Mountain View Electric Association, Inc. (MVEA) has these comments about the following:

Project Name: 10595 Milam Road, Sanford Subdivision #4

Project Number: VR-17-016

# SANFORD SUBDIVISION FILING NO. 4 AN AMENDED PLAT OF LOTS 2 AND 3, SANFORD SUBDIVISION FILING NO. 3

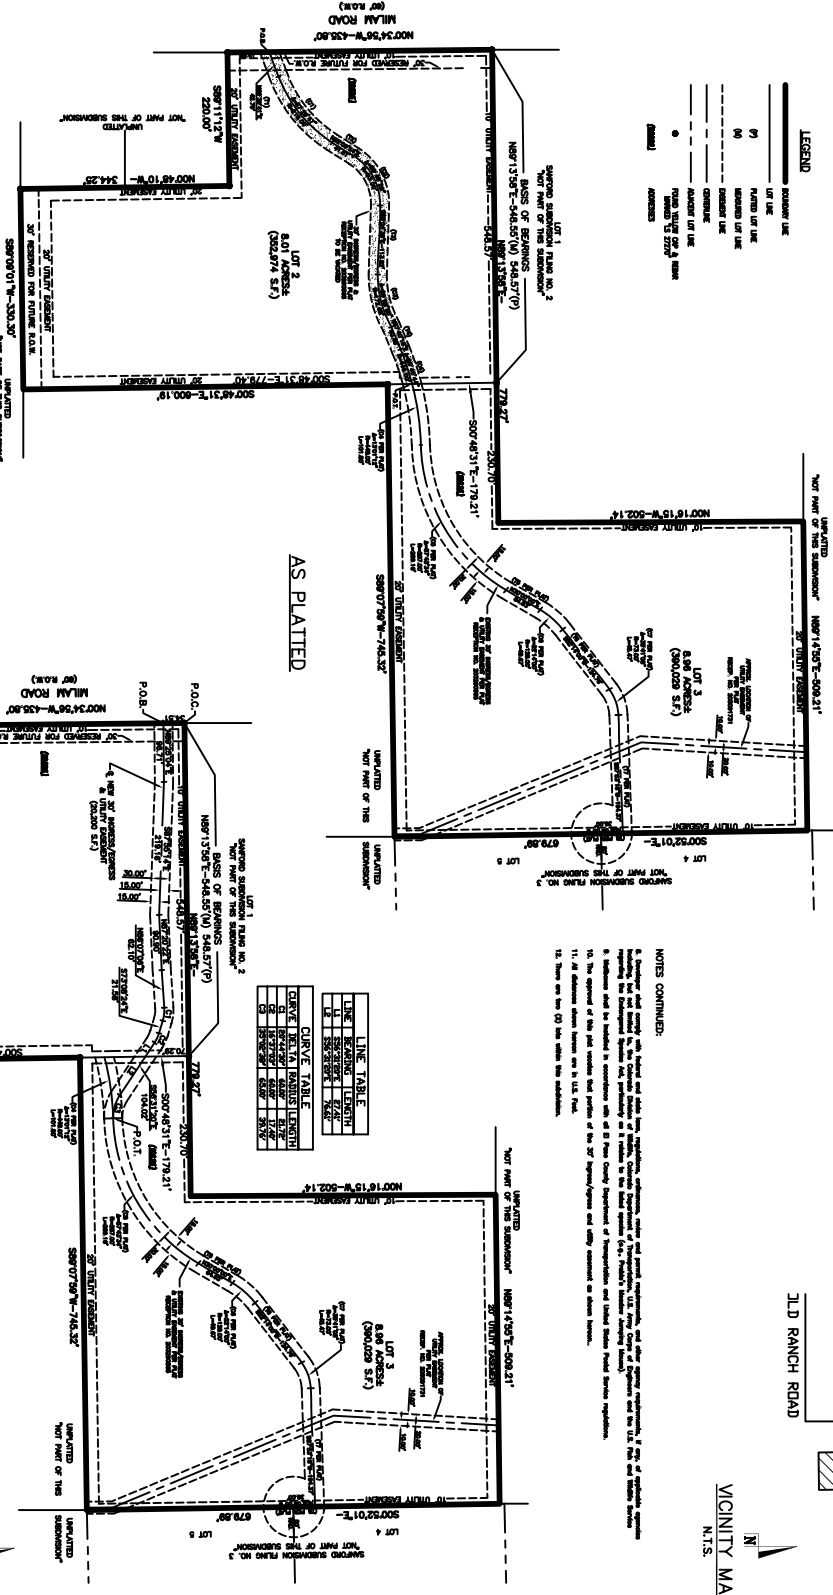
MVEA requests the public utility easements of ten (10) foot all sides lot line along with twenty (20) foot exterior subdivision utility easements following the design as platted in the original Sanford Subdivision #3.

MVEA has no objection to the new design of Lot 2 and 3 to relocate the driveway for access to Lot 3.
